**Consultation Response from KC,
Highways Development Management****2025/91616 Upper Bankfield Mills, Almondbury Bank, Almondbury, Huddersfield, HD5 8HF****Erection of concrete plant****Date Responded: 3-9-2025.****Responding Officer: Mark Berry.****Responding Ref: 5-10SE-22.**

This application seeks approval to the erection of a concrete plant at Upper Bankfield Mills, Almondbury Bank, Almondbury, Huddersfield.

Location Plan

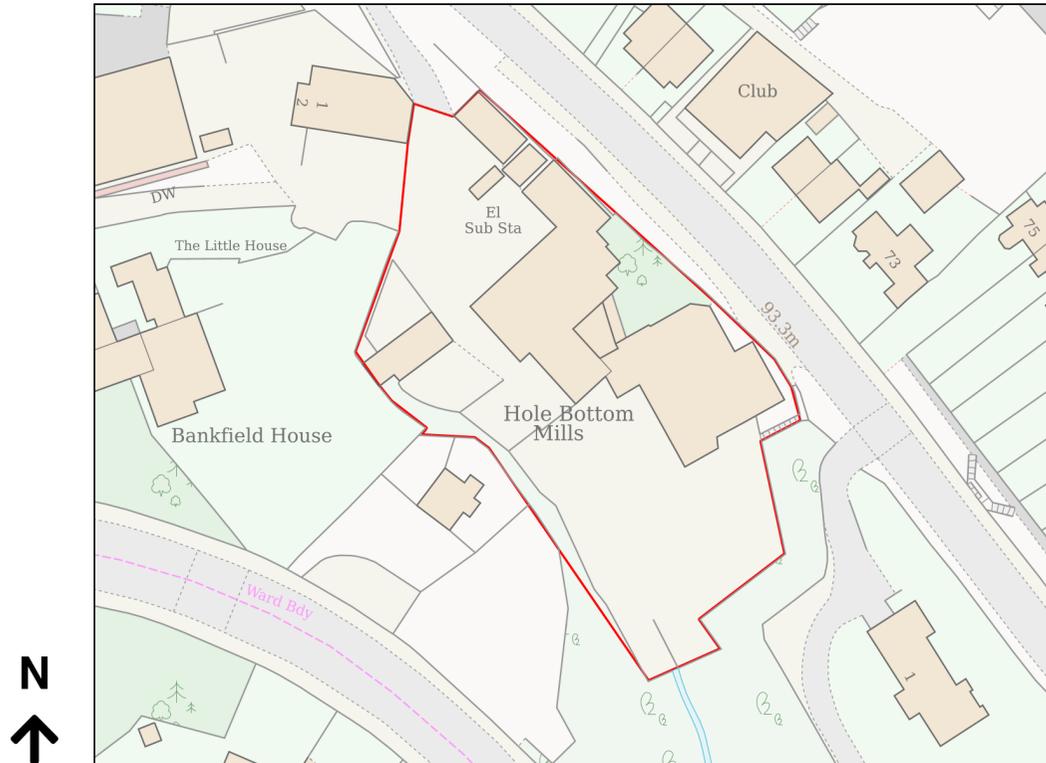
The proposals show a proposed concrete plant located on the southern side of the Banksfield Mill complex. Access is via the existing access onto Almondbury Bank.

No information is provided regarding parking, HGV parking, storage, internal vehicle turning arrangements or the anticipated number of vehicle movement.

The existing access meets Almondbury Bank at an acute angle which will result in difficult turning movements particularly for larger vehicles. The access is steep and narrow (not wide enough to allow two vehicles to pass), and there are no footways. The sight lines from the access onto Almondbury Bank are poor in both directions.

This proposal will be an intensification in the use of an access which is severely sub-standard in terms of its alignment, width, gradient, footway provisions and sight lines onto Almondbury Bank. Highways Development Management have therefore no option other than to recommend refusal on highway safety grounds.
